WEST SUSSEX COUNTY COUNCIL CONSULTATION

TO:	Arun District Council FAO: Hebe Smith
FROM:	WSCC – Highways Authority
DATE:	12 March 2026
LOCATION:	2 Downview Road Arundel BN18 0HS
SUBJECT:	Y/5/26/PL Erection of terrace of 4 No town houses with gardens and parking spaces. This application is in CIL Zone 2 and is CIL Liable as new dwellings.
DATE OF SITE VISIT:	n/a
RECOMMENDATION:	More Information

2 Downview Road, Yapton : Proposed 4-unit 3-storey Terrace of 3-bedroom Dwellinghouses : PROPOSED SITE LAYOUT

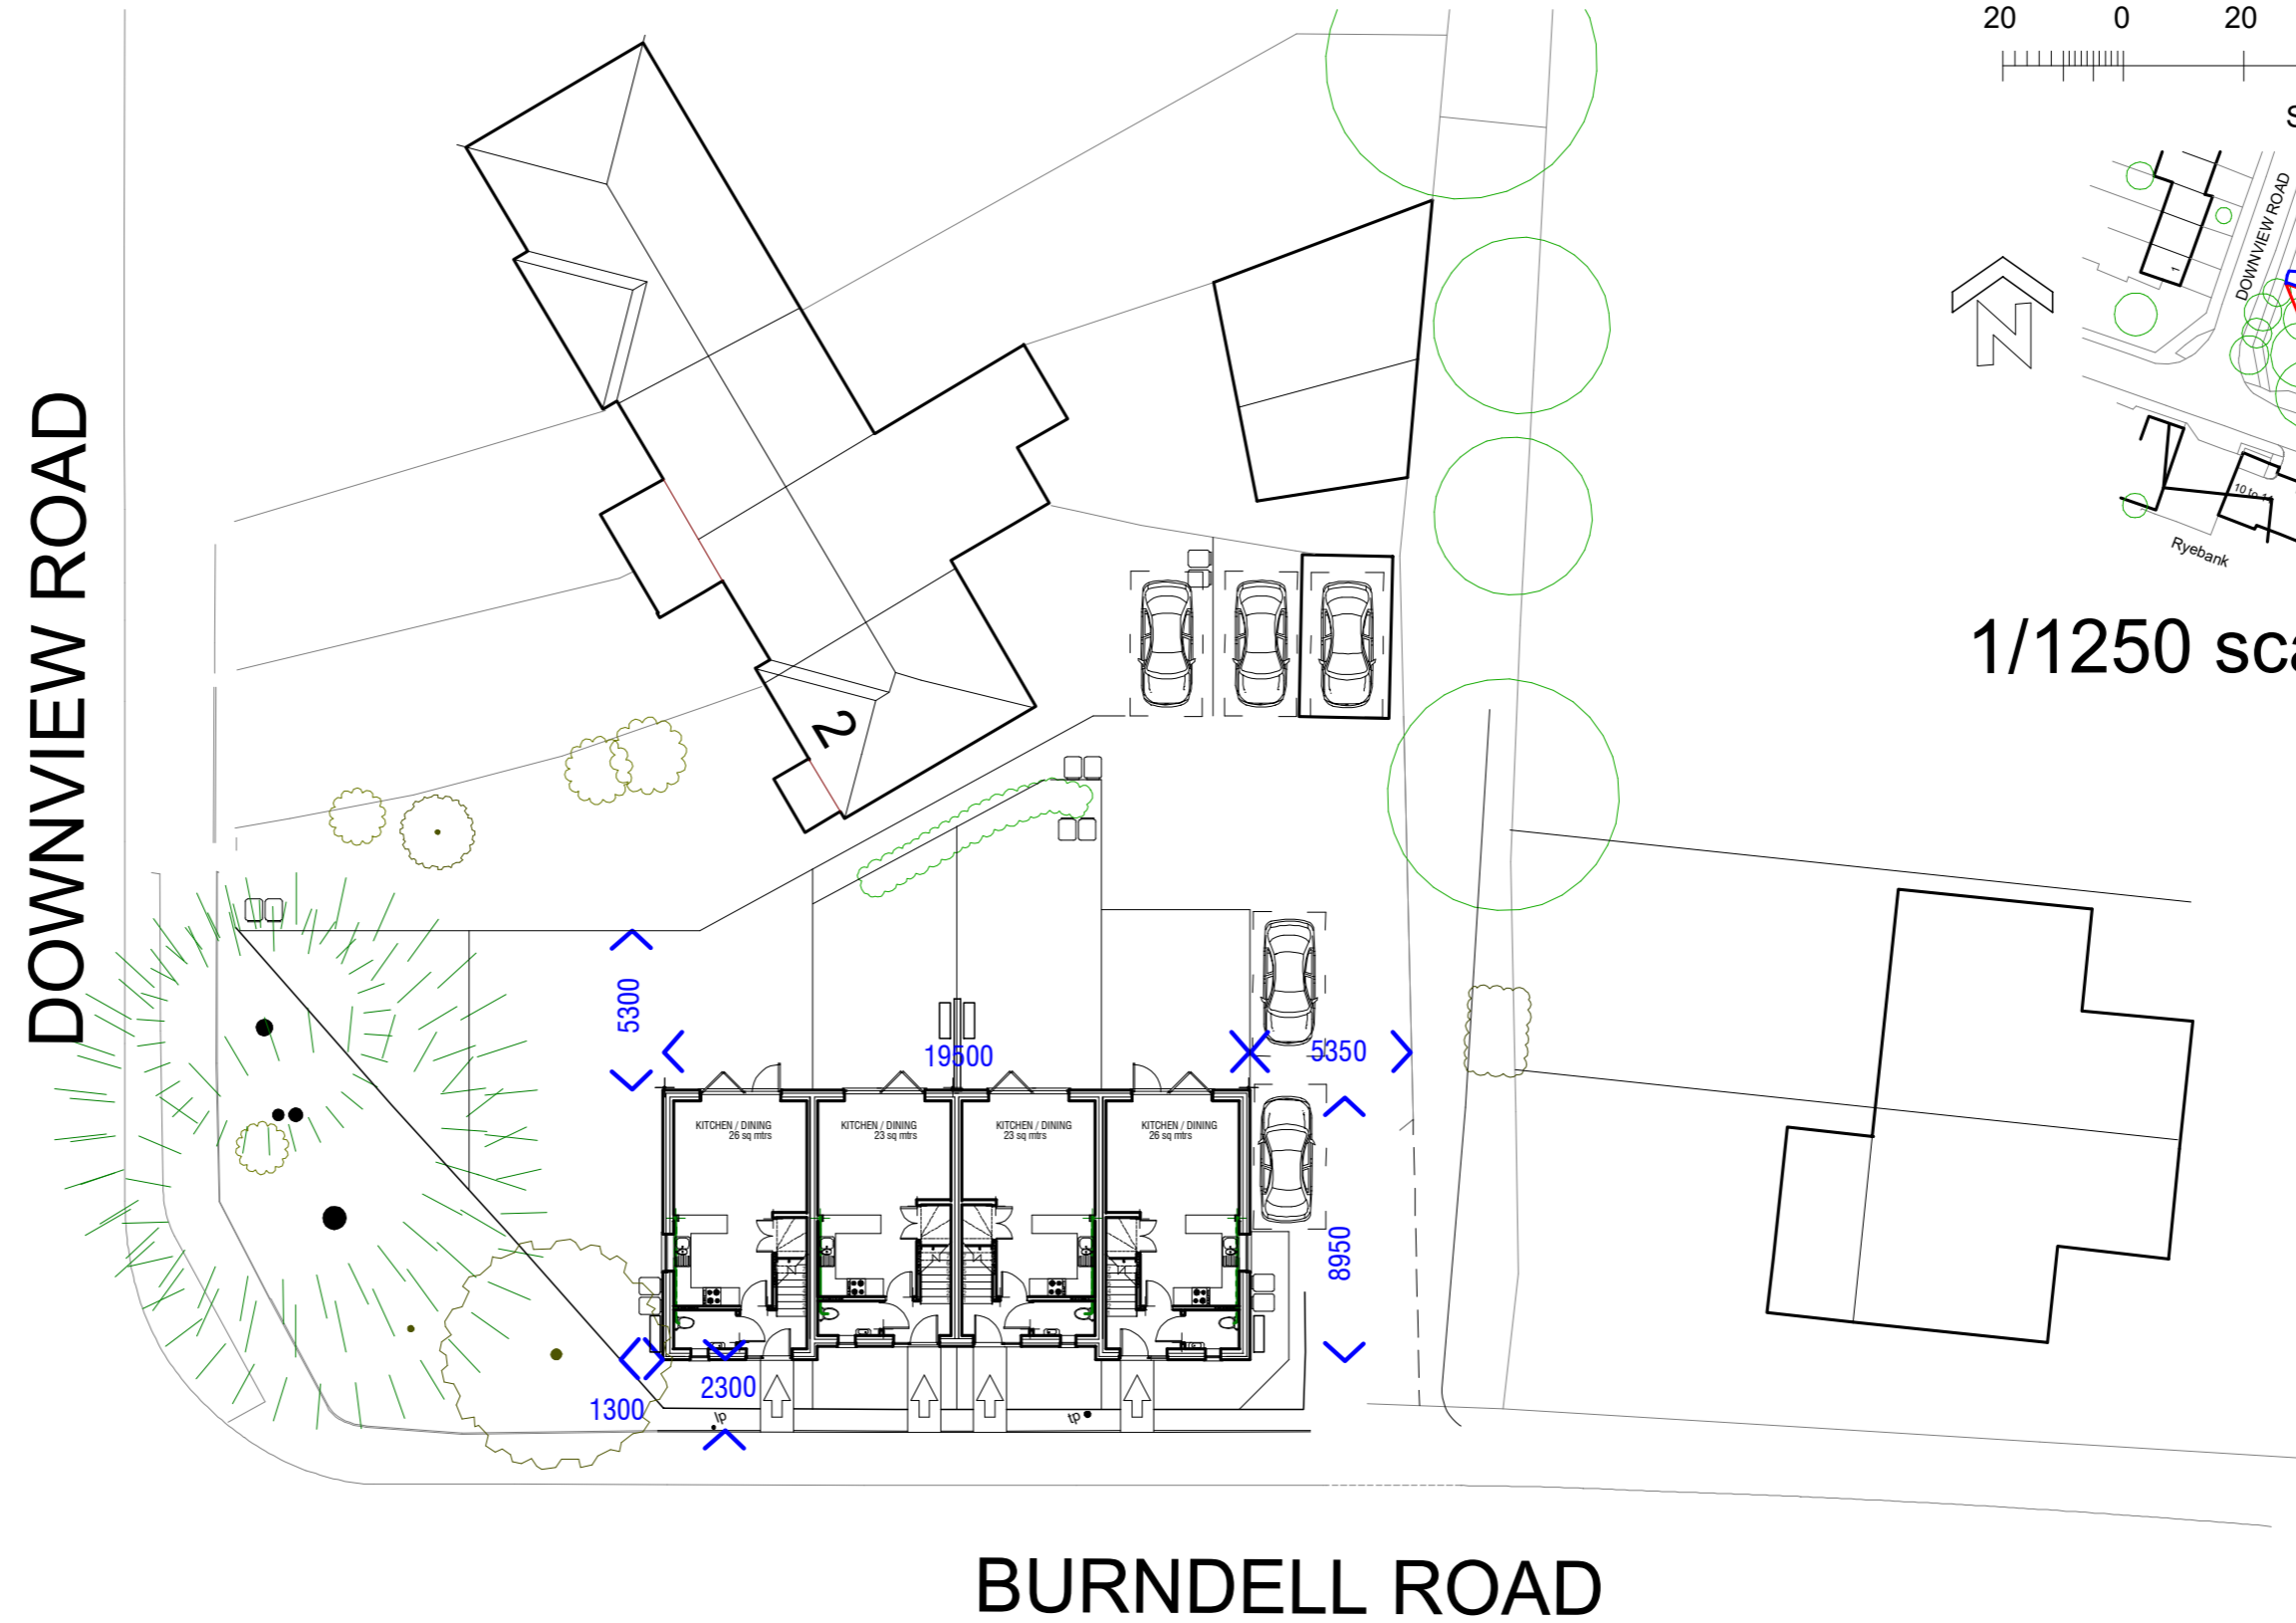
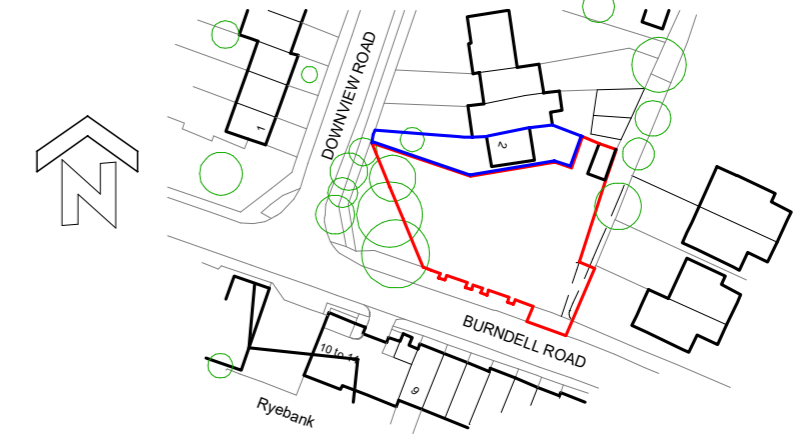
The proposed dwellings and amenity land appear to be sited partially on land which is publicly maintained highway, the use of this land would be subject to a successful Stopping Up process to formally remove the highway rights. The length of verge fronting Burndell Road at this location is publicly maintained highway. From scaling and measuring the plans, it appears that the dwellings are to be sited approx 4m from the edge of the carriageway and the frontage amenity space extends within even closer proximity to the existing footway.

The verge proposed to be incorporated does form part of the public highway. For the land to be incorporated into the site, the highway rights would need to be formally removed by way of a Stopping Up Order. This would be subject to a separate process administered by the Department for Transport's National Casework Team. The Highway Authority along with other statutory undertakers and interested parties would be consultees in this process. The "Stopping Up" process would follow any granting of planning permission, however there is also no guarantee that this process would be successful. The comments made here would not constitute the Highway Authority's formal position regarding any future Stopping Up.

If the applicant does not intend to explore this route, it would be advised that the design of the development is reconsidered to allow unobstructed access to the publicly maintained verge in this location.

The development represents an intensification of use of the existing access onto Burndell Road, visibility splays should be provided from the site access to demonstrate that the proposed amenity land would not impede on visibility along the carriageway in the leading direction. Visibility splays should also not be impacted for users emerging from Downview Road. For a 30mph road such as this, visibility splays of 2.4m x 43 m should be achievable in line with Manual for Streets parameters.

The parking distribution has not been acknowledged within any of the associated documentation, however, appears to provide a single space per dwelling and a parking space for the host dwelling.

The three parking spaces to the north of the site appear workable, there are a further two parking spaces to the east of the dwellings. Vehicles will be encouraged to park in parallel at this location. Where it is the case that tandem vehicles will be parked by users of different households, it would be considered that a 2m x 6m parking bay would be sufficient to allow a vehicle to navigate into the space (in this instance in the southern tandem space- with no clear space to the rear). This facilitates sufficient space for a vehicle to manoeuvre and make use of the parking allocation if a vehicle was parked in the opposite bay. A smaller allocation than 6m in this space may cause issues with amenity, preventing users from making use of the parking provision.
